DEVELOPMENT REVIEW BOARD

Planning Dept. - Major Case Comments

Project Number: PR-2019-002496

Project Name: Alameda Barstow Apartments

① Phase A-South
1/8" = 1'-0"

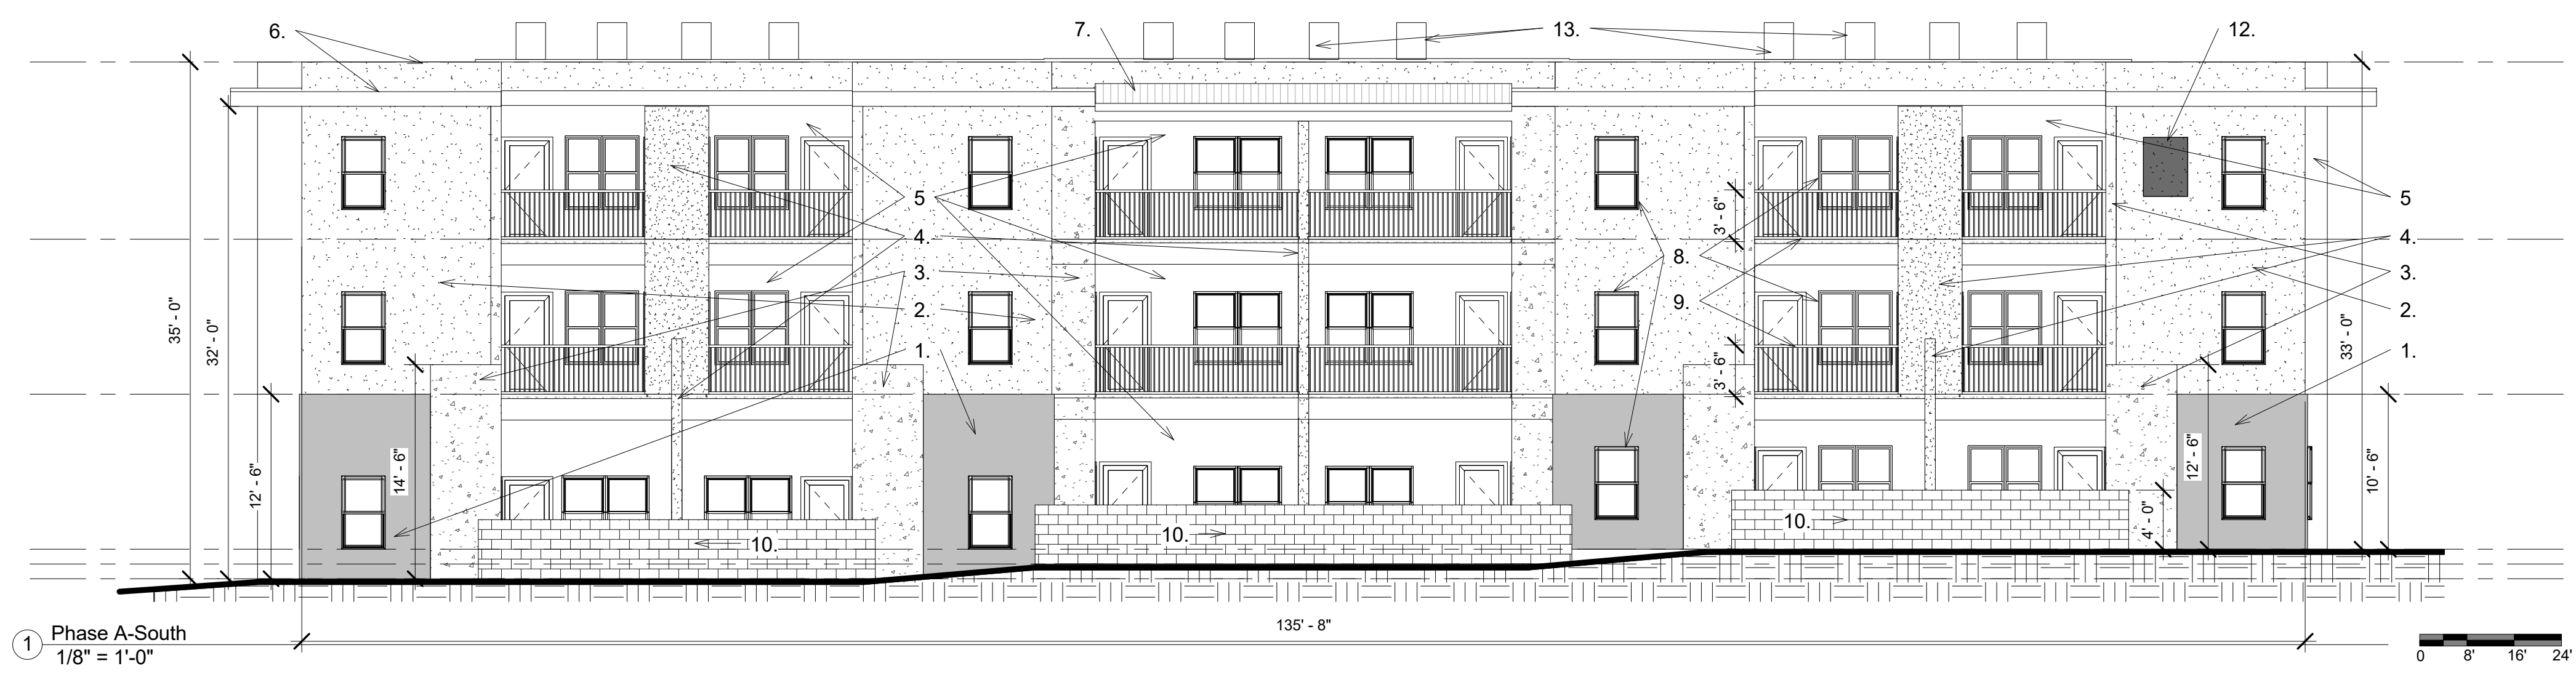
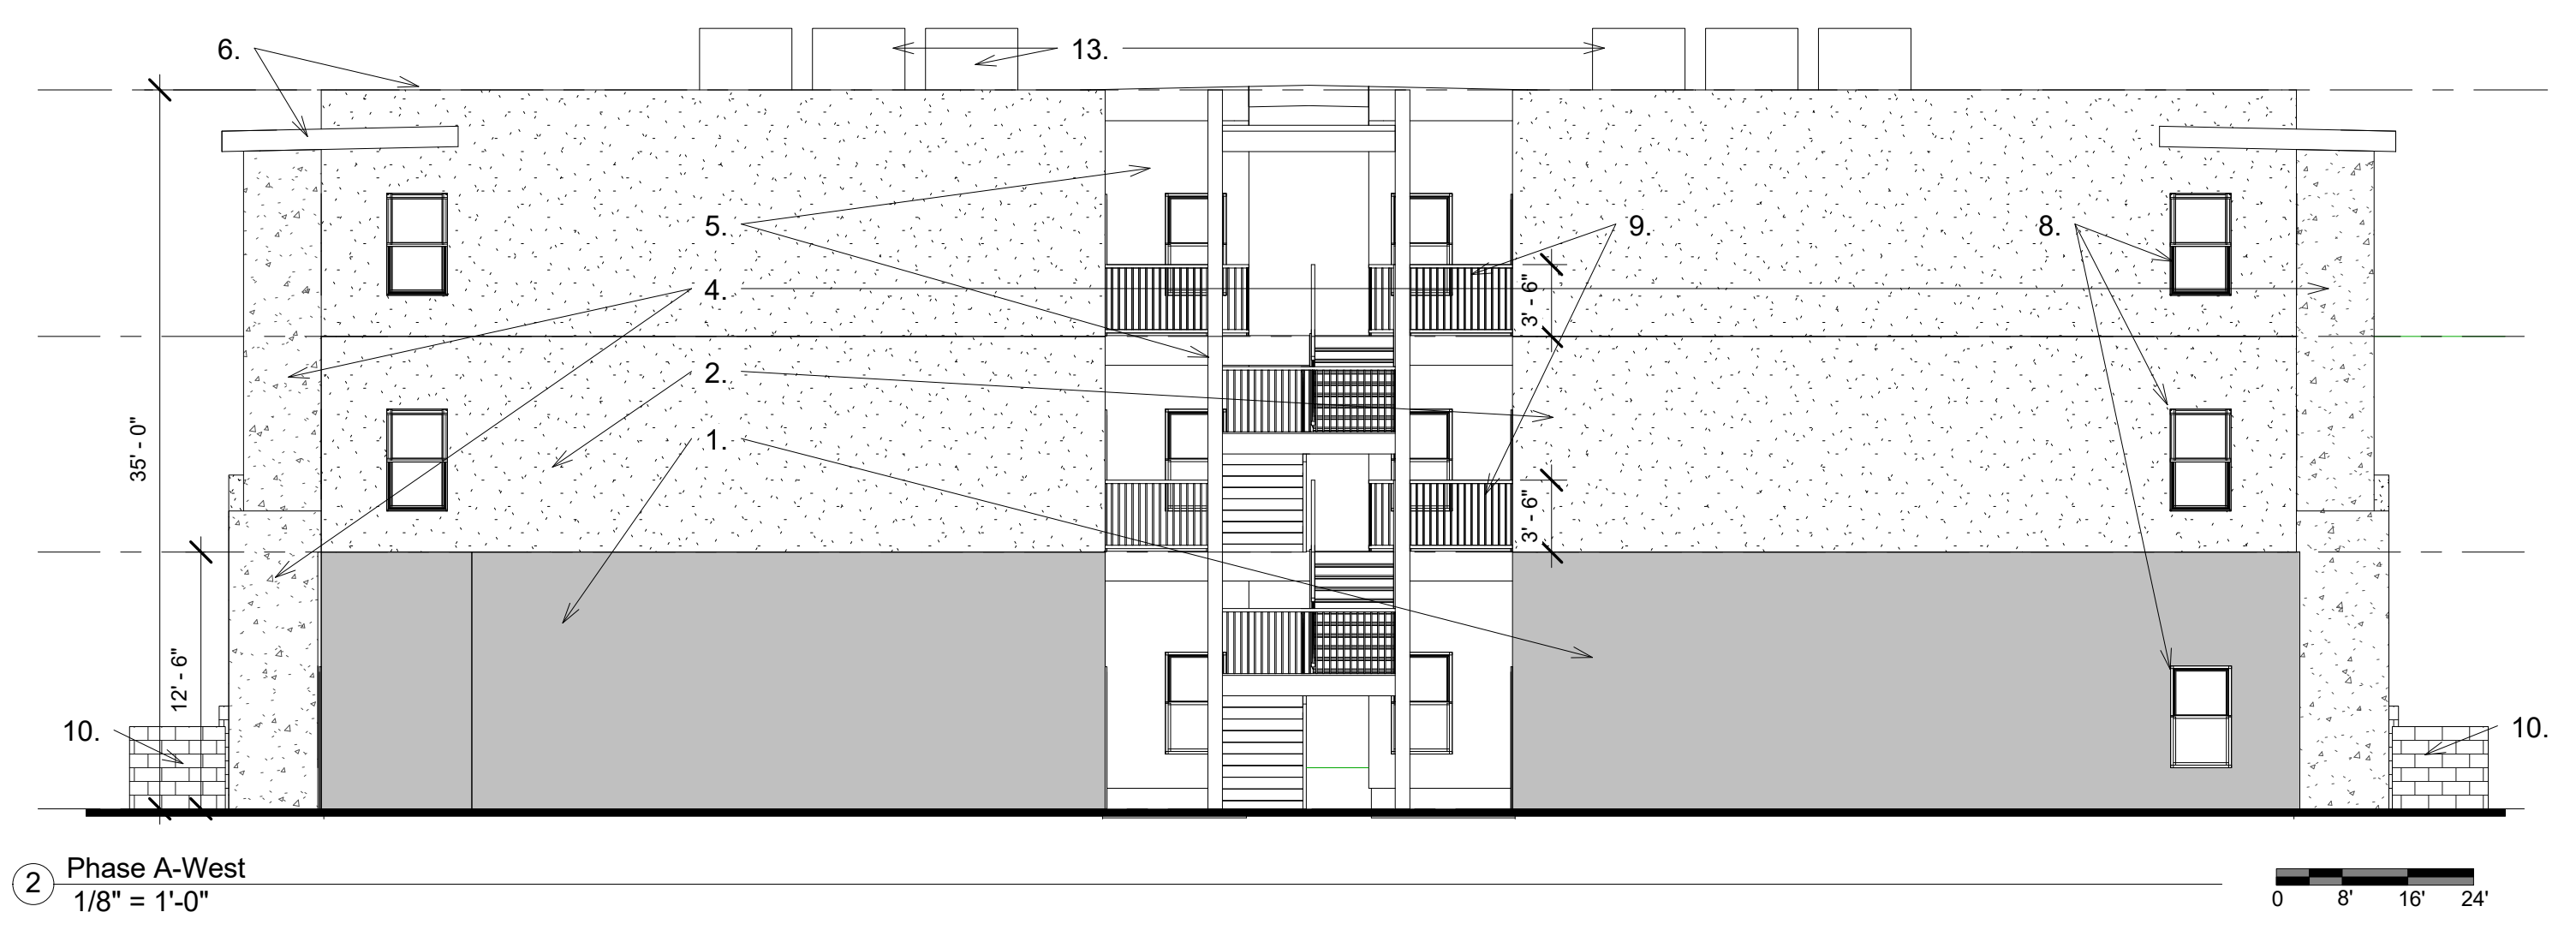
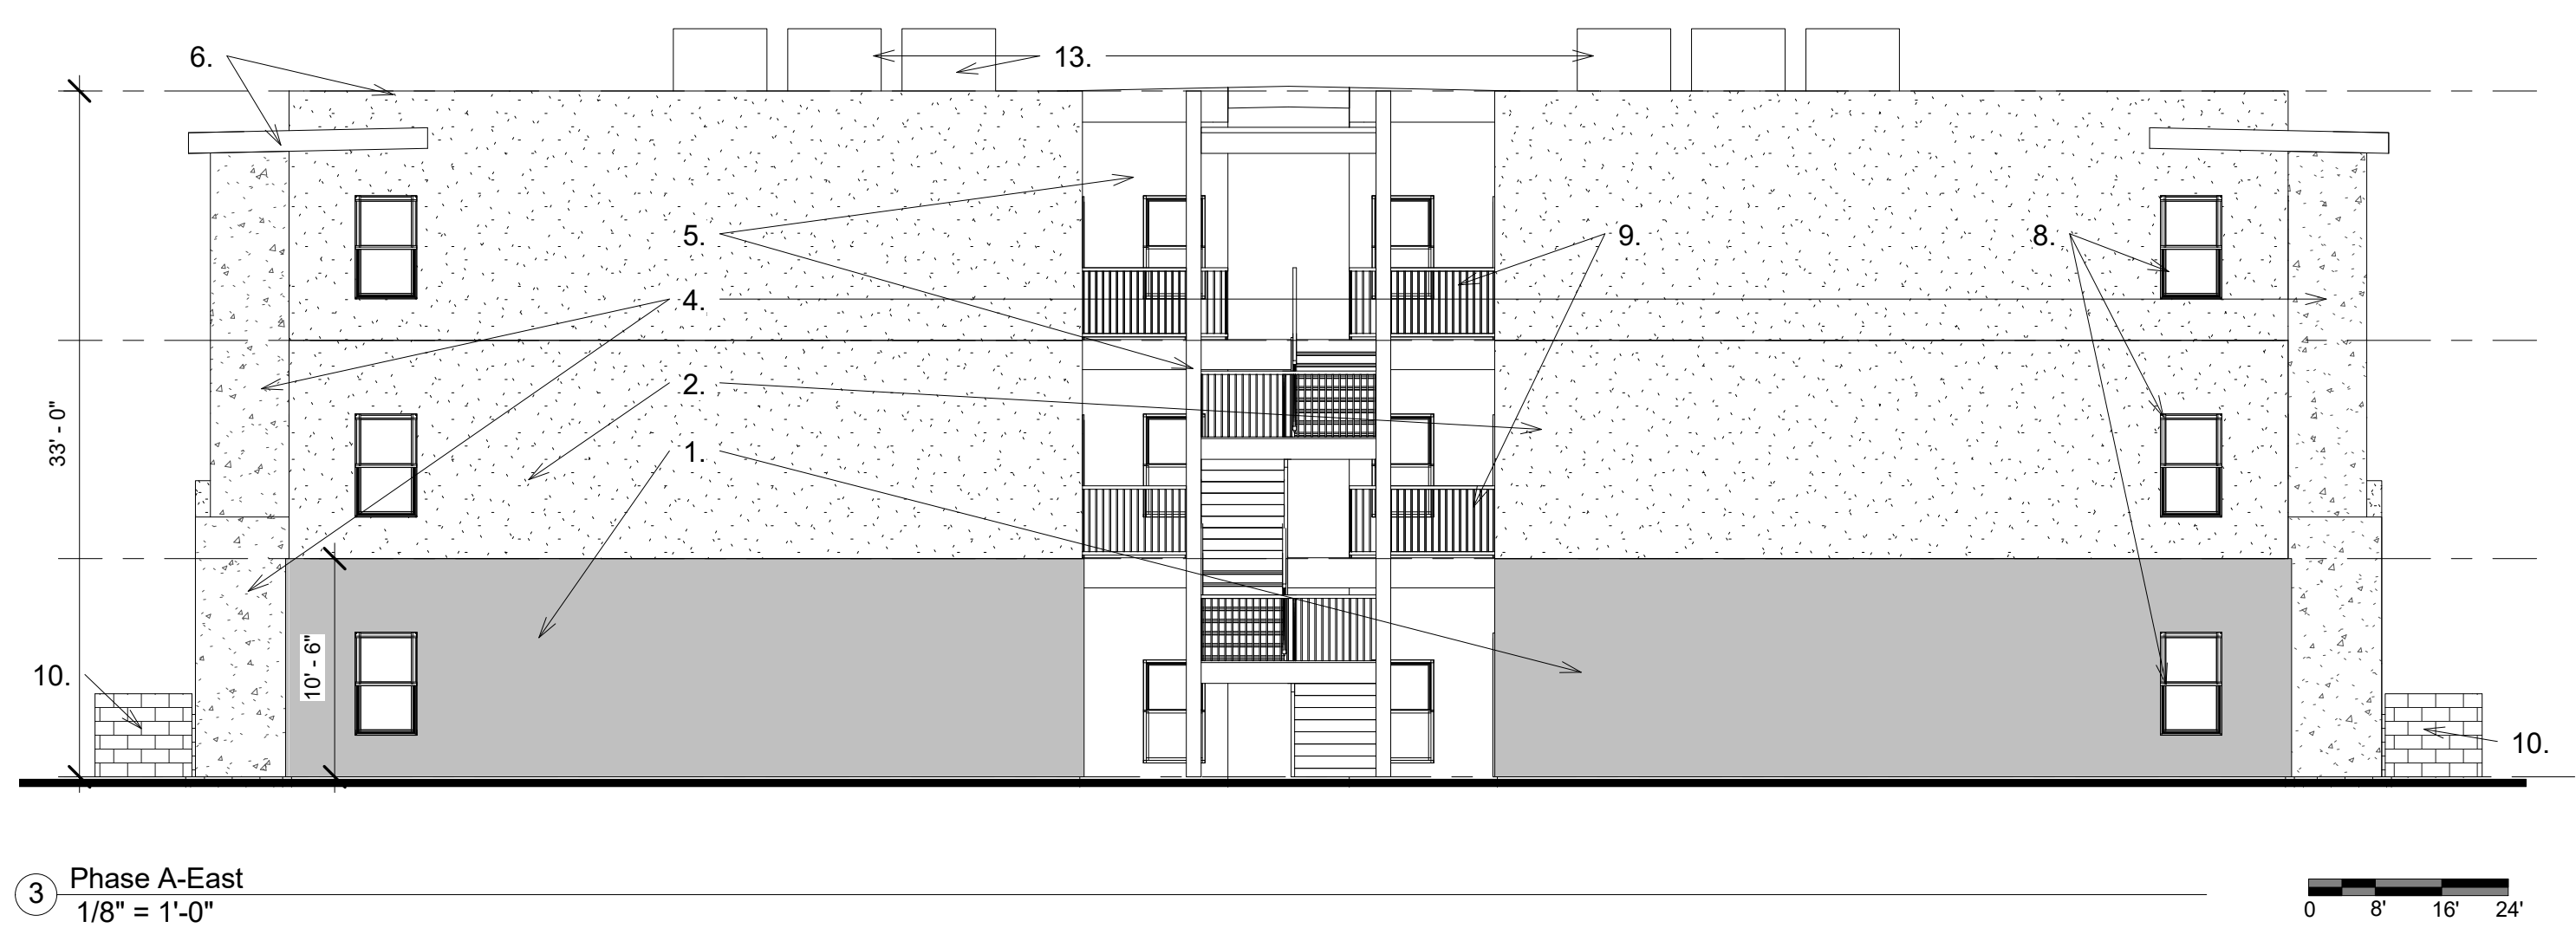
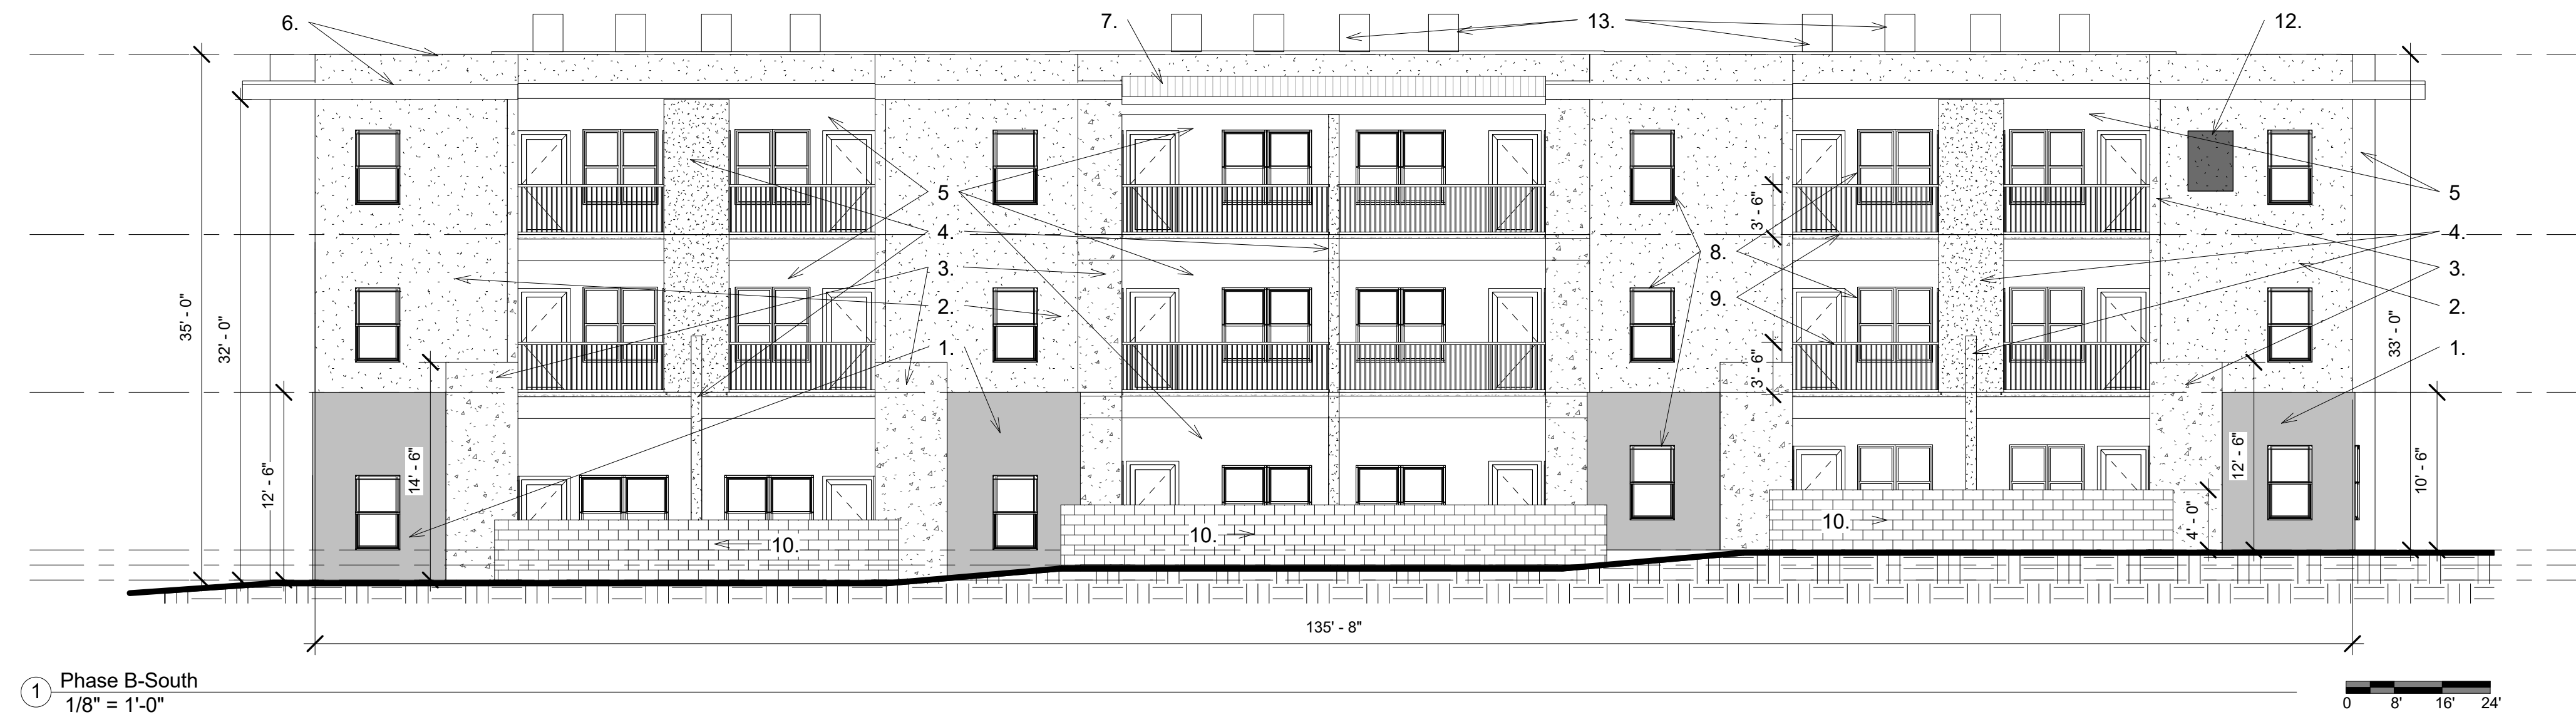
1. We need more information on the lime green structures/features (as to what they are). These are shown on the color rendering.
2. The standards in 5-11 require that each façade facing a public street shall incorporate at least 2 of the following features along at least 30 percent of the horizontal length of the façade. The features listed below shall be distributed along the façade so that each horizontal façade length of 40 linear feet contains at least 1 of the following features: Please clarify the percentage of windows along the horizontal length.
3. Please clarify the roofline- the color rendering appears to show variation, the elevations do not.
4. Please clarify the building and phasing labels- buildings are labeled as phases.
5. Clarify the identity of what is being constructed in the open space.
